Preliminary and Final DRAINAGE PLAN AND REPORT

ROCKY TOP MOTEL AND CAMPGROUND

June 14, 2019

County File No.: PPR2140

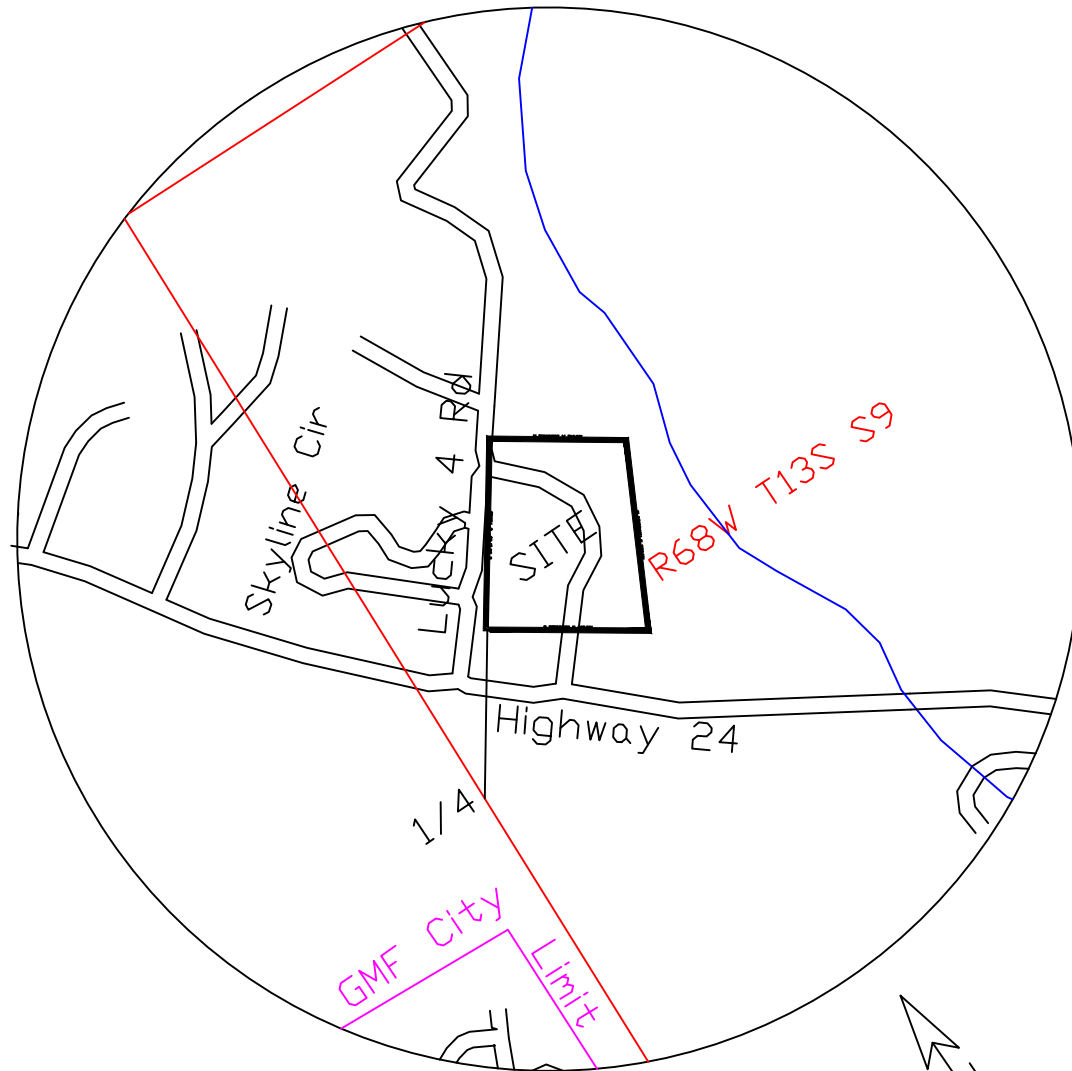
Transmitted herewith for your review and approval is the drainage plan and report for The Rocky Top Motel and Campground in El Paso County. This report is prepared and a result of Craig Dossey's letter of May 2, 2019 regarding an alleged violation of County grading regulations. It has been revised per the 10-7-21 County Review and our subsequent meetings. This report will accompany the submittal of other land use applications. Please contact me if I may provide any further information.

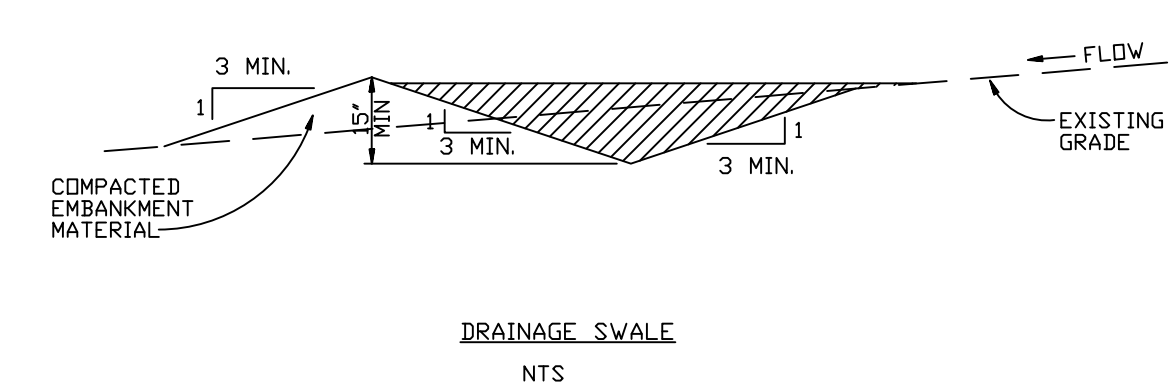
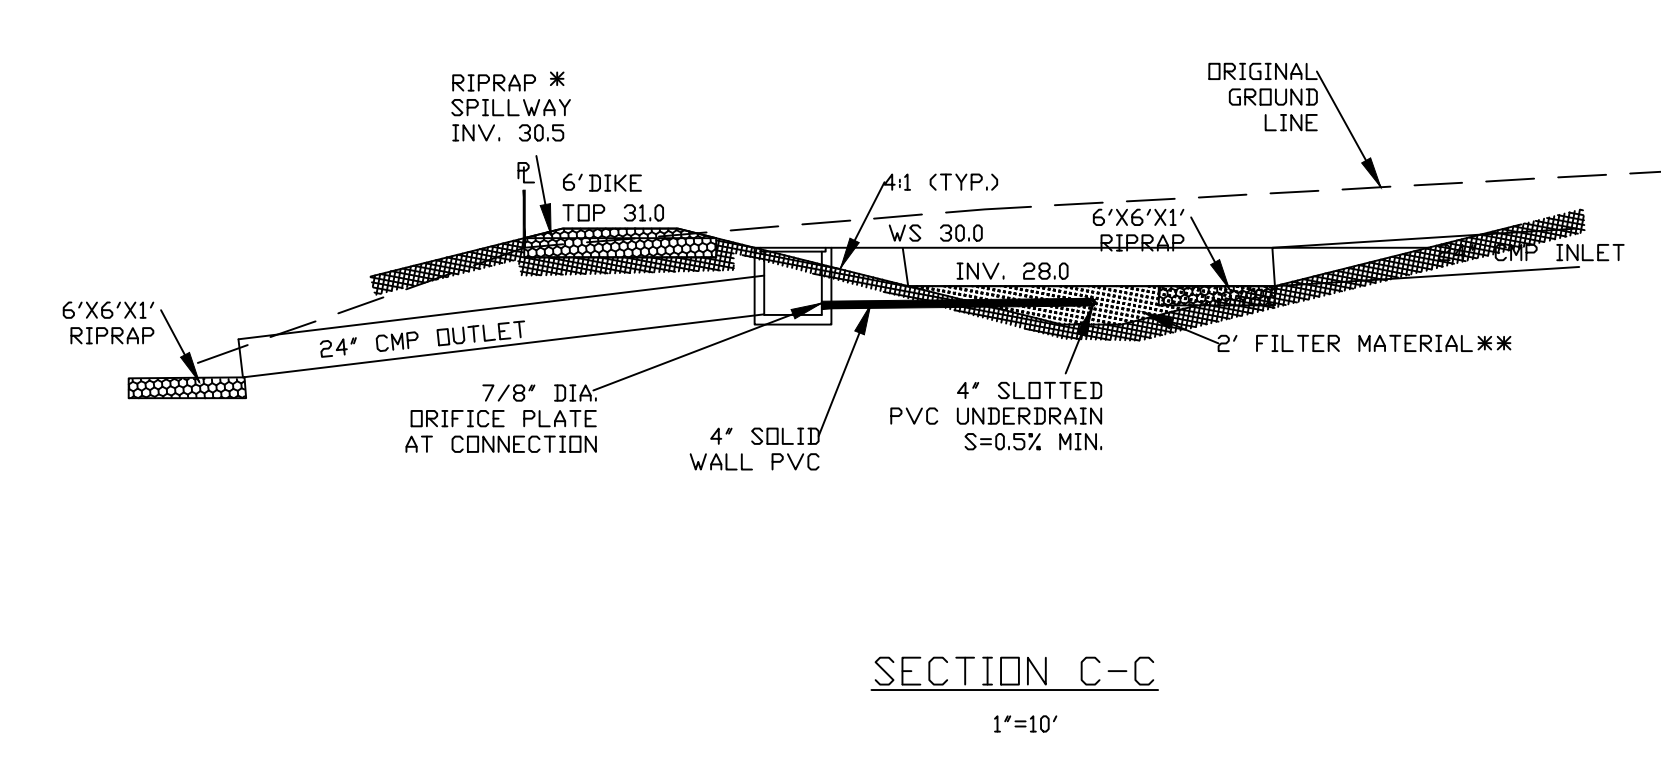
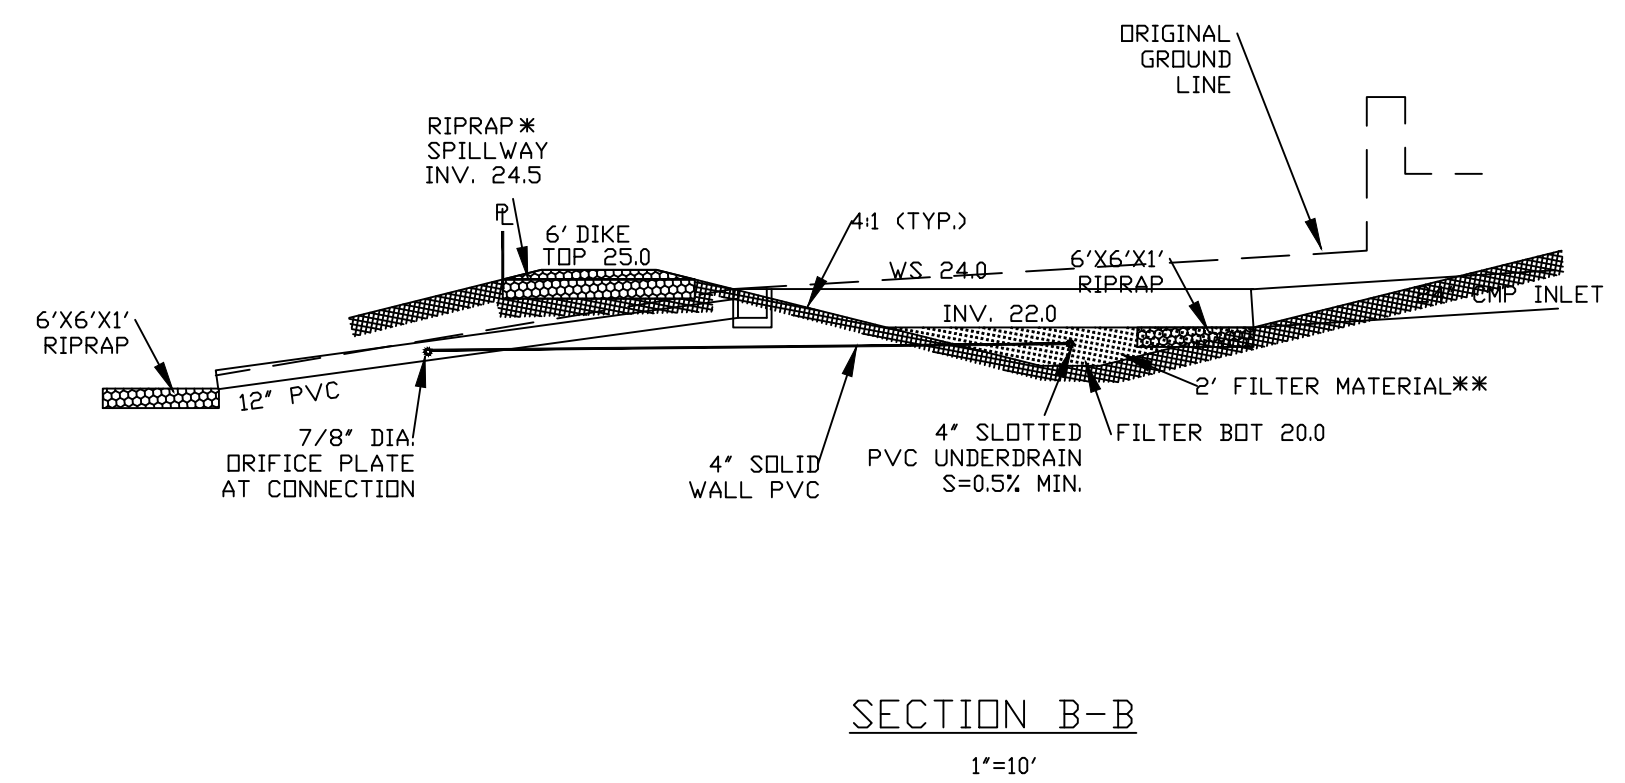
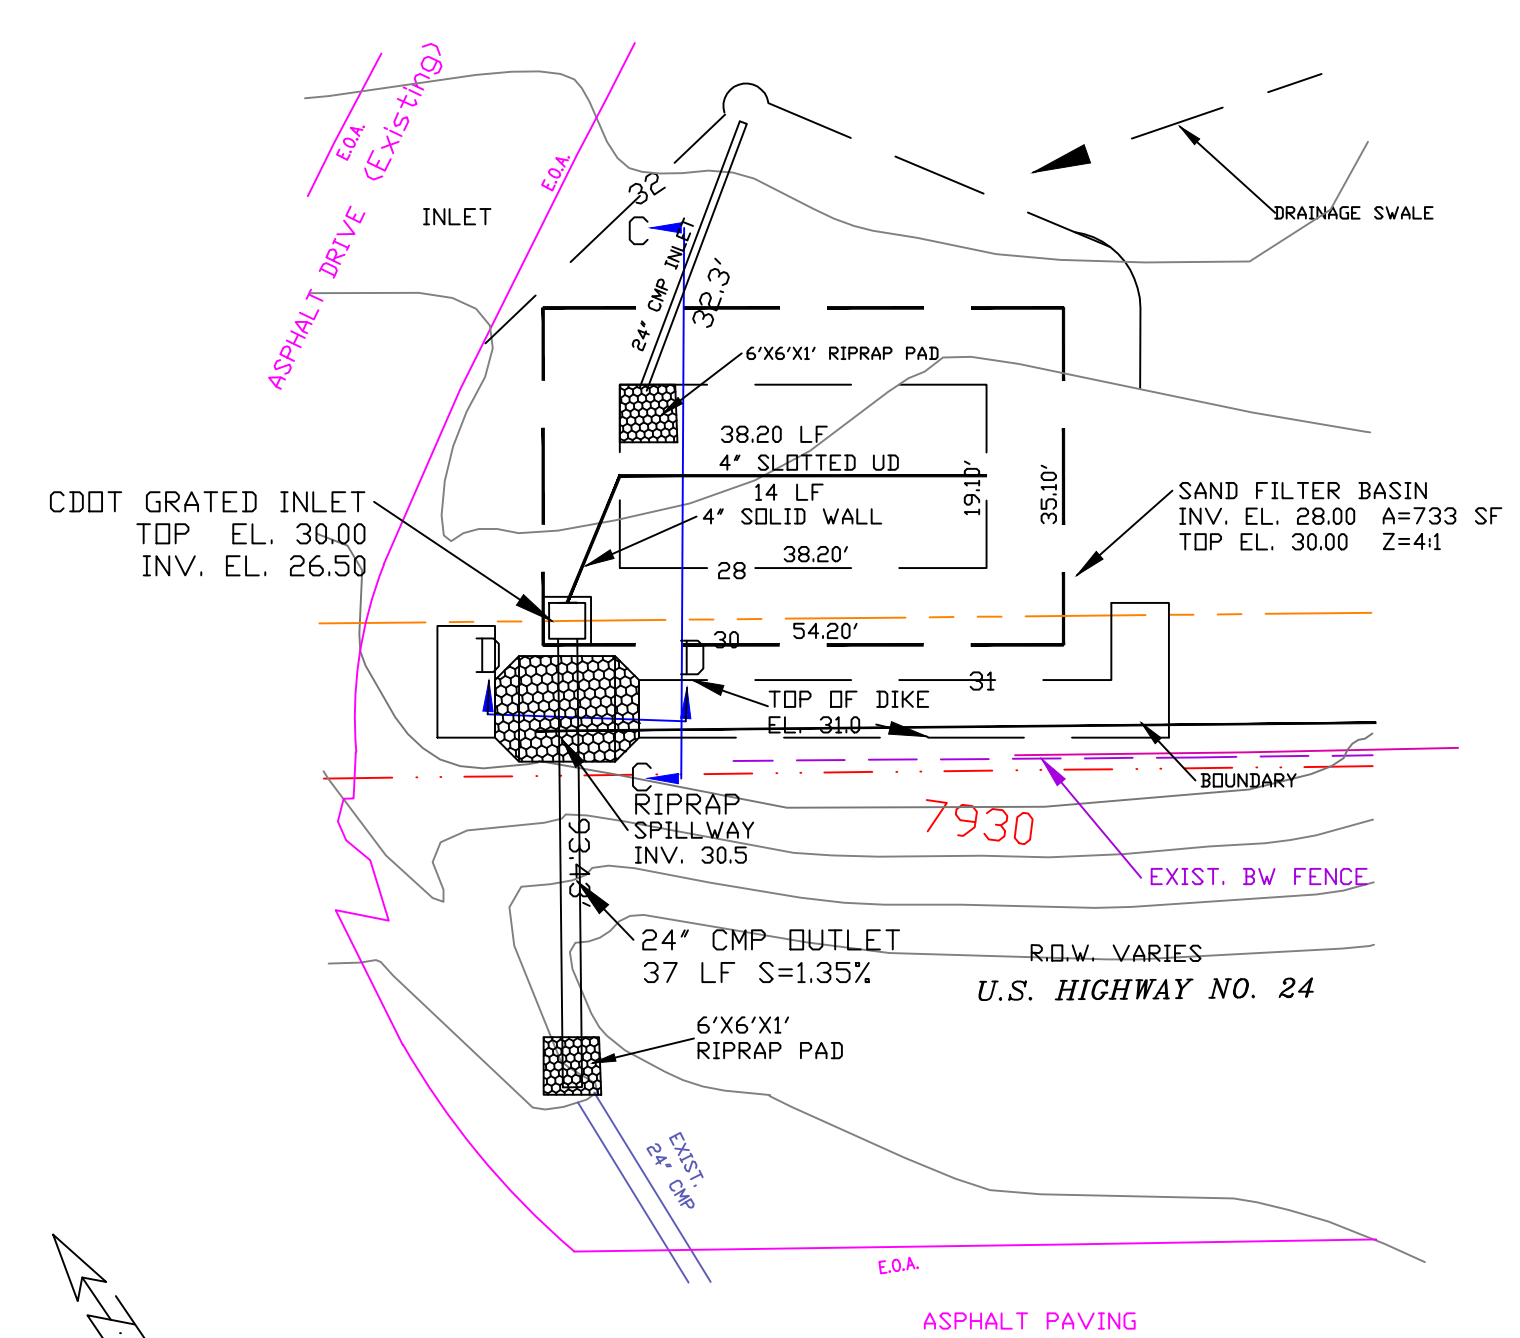
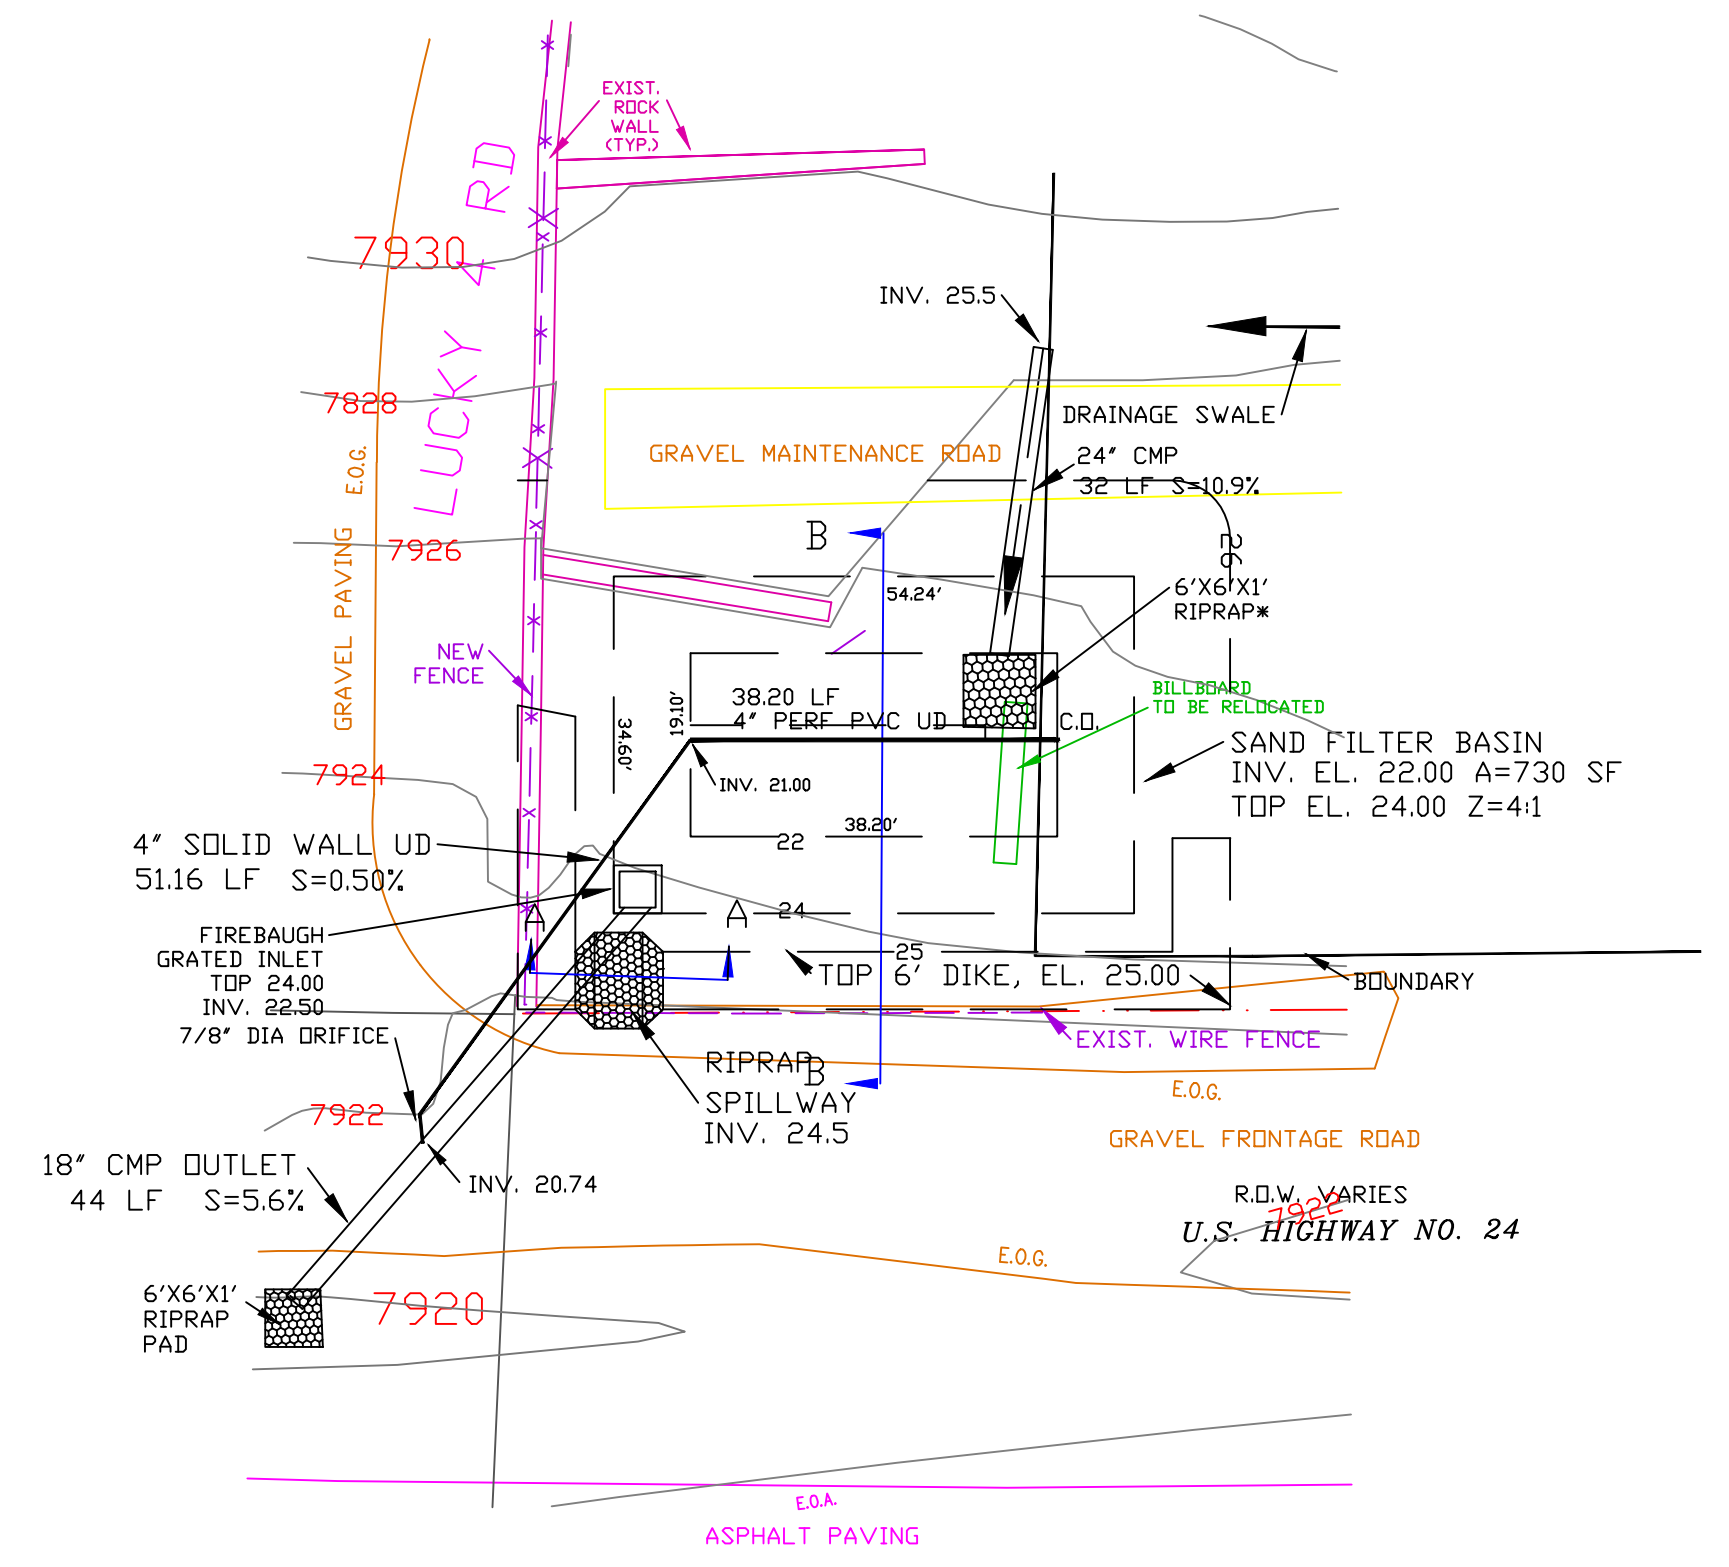
Also complete the MHFD UD-Detention worksheet to show change from existing to proposed flows and to calculate the orifice hole dimensions in the outlet. Currently shown on plans as 7/8" but no calcs provided to support that.

Also complete the MHFD UD-Detention worksheet to show change from existing to proposed flows and to calculate the orifice hole dimensions in the outlet. Currently shown on plans as 7/8" but no calcs provided to support that.
